KITTITAS COUNTY COMMUNITY DEVELOPMENT SERVICES

RE: Ackroyd Parcel Combination (CB-19-00001)

Community Development Services received the above referenced application on January 14, 2019. The application has been reviewed and processed by staff and **preliminary approval** is hereby granted with the attached comments. Pursuant to Kittitas County Subdivision Code Chapter 16, please note the following items must be completed prior to final approval of the parcel combinations and must be submitted to our offices for review:

LOCATION OF EXISTING
STRUCTURE

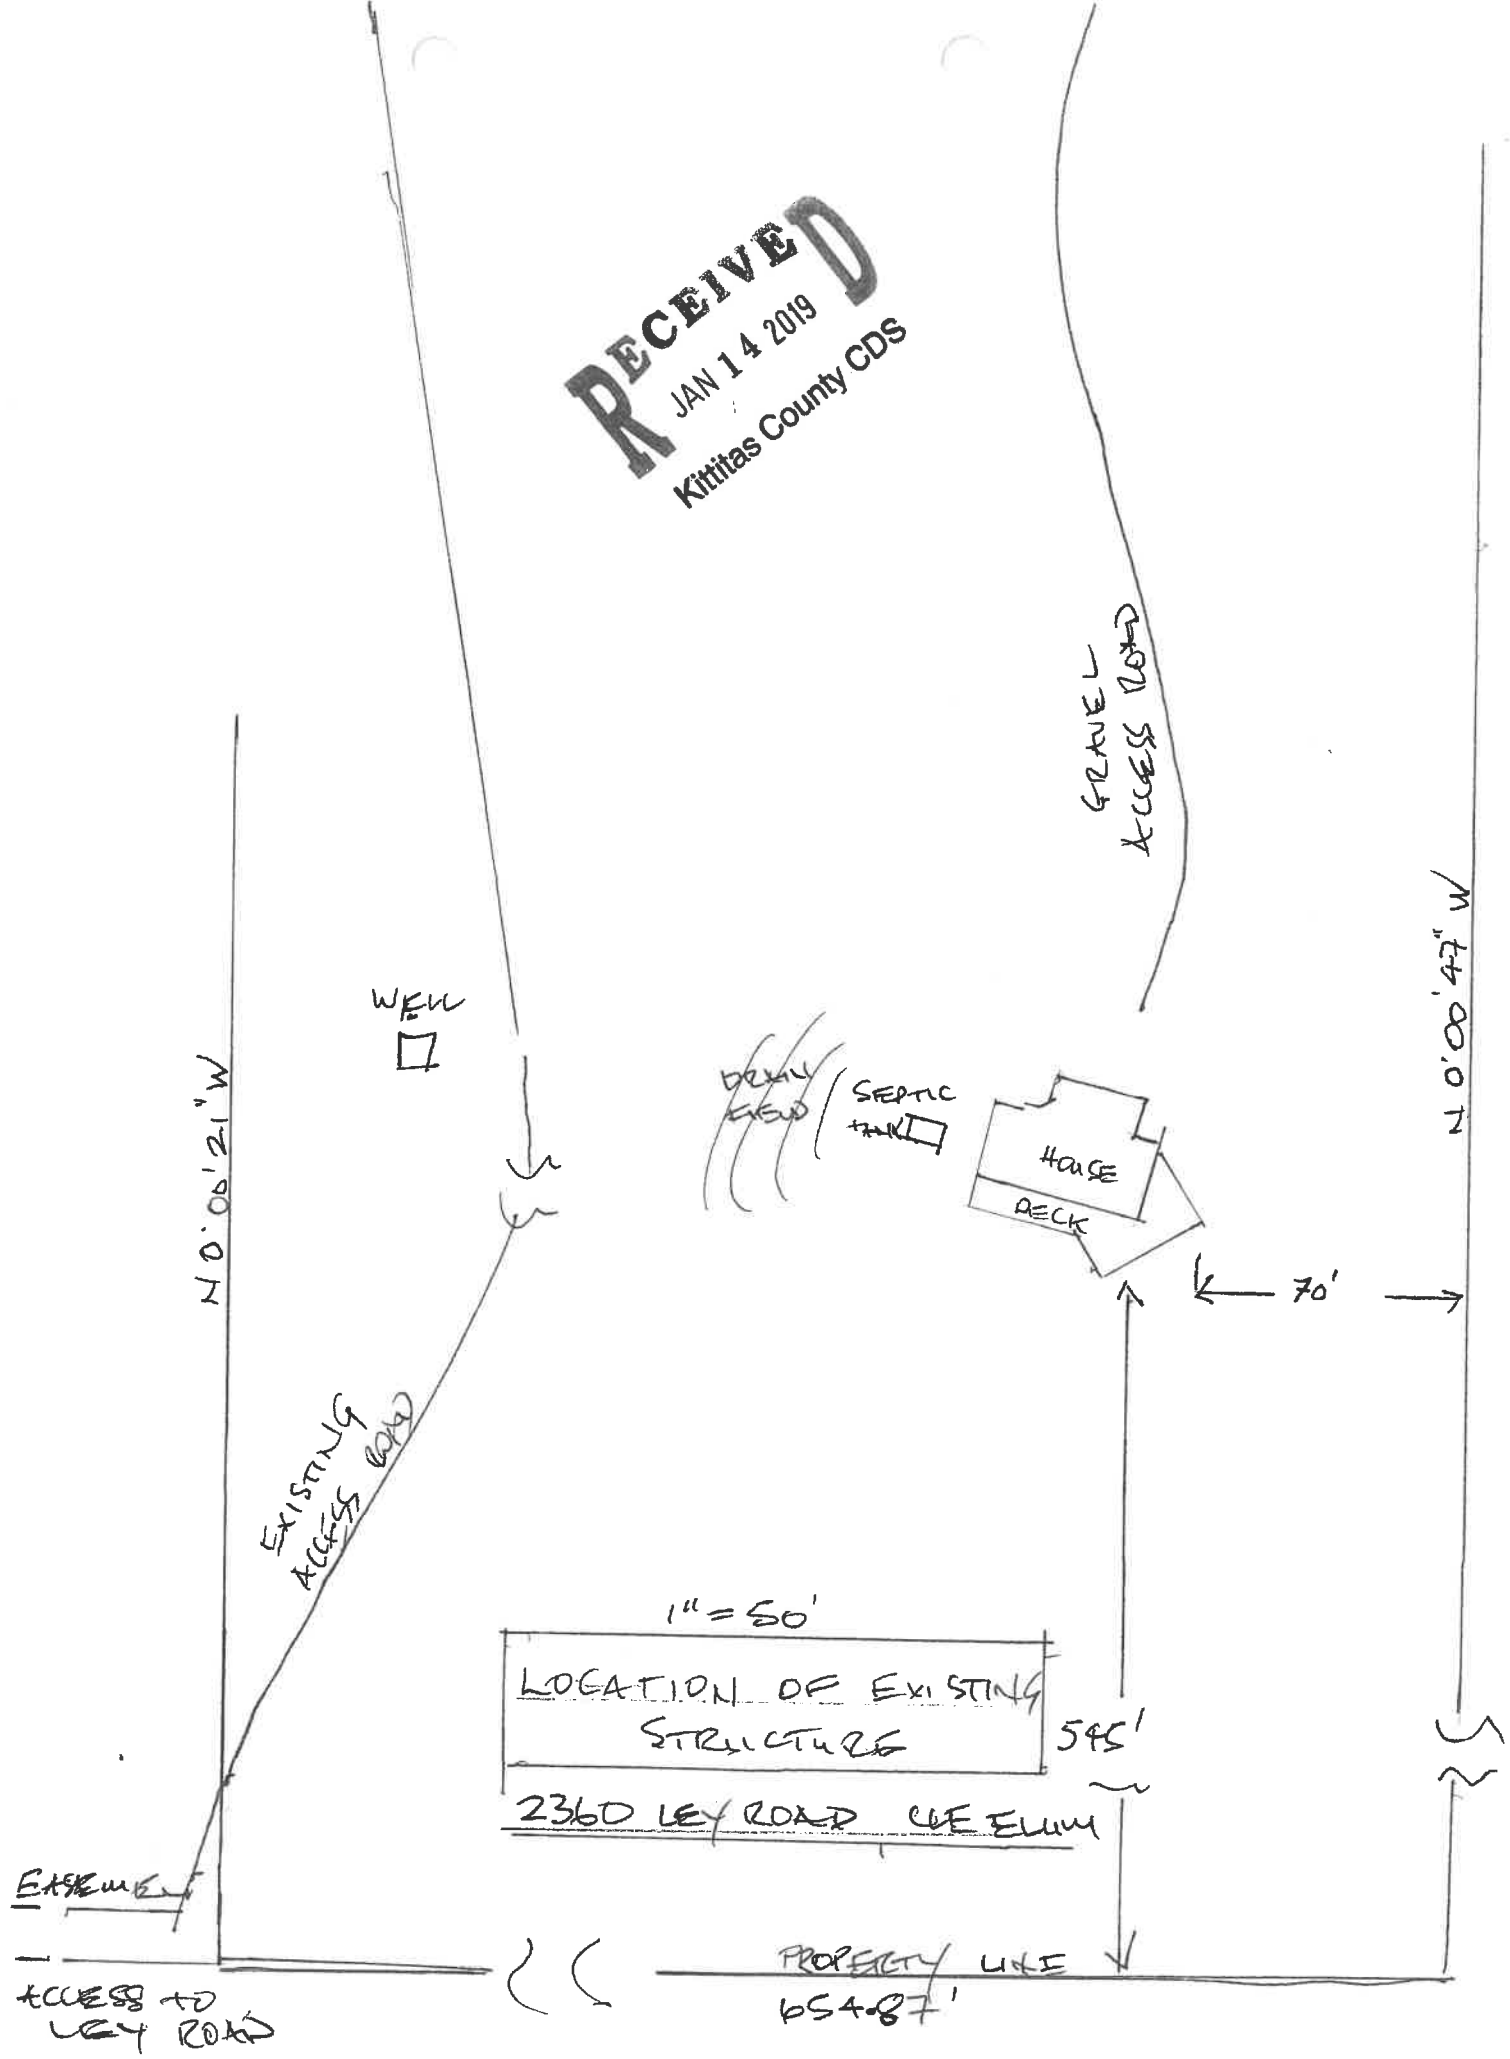
The only reason I asked for the distance that the well is from the property line is because the well looks like it is inside of the 1 acre square with the house and the septic system. I thought I understood that the rest of the parcels were being combined except for this one remaining acre. Did I understand correctly or did I miss something?

Thank you for this opportunity to comment. On the site plan provided, the distance from the property line to the well is unclear. A scale is provided but following that scale, the well doesn't meet the required 50 foot property line setback. Public health needs to know the distance the well is from the proposed property line.

The 1 acre piece is only for tax purposes, it is truly not its own parcel.

This is a parcel combination so there are no lot lines being moved. Do you still need to know the well setback?
Thank you!
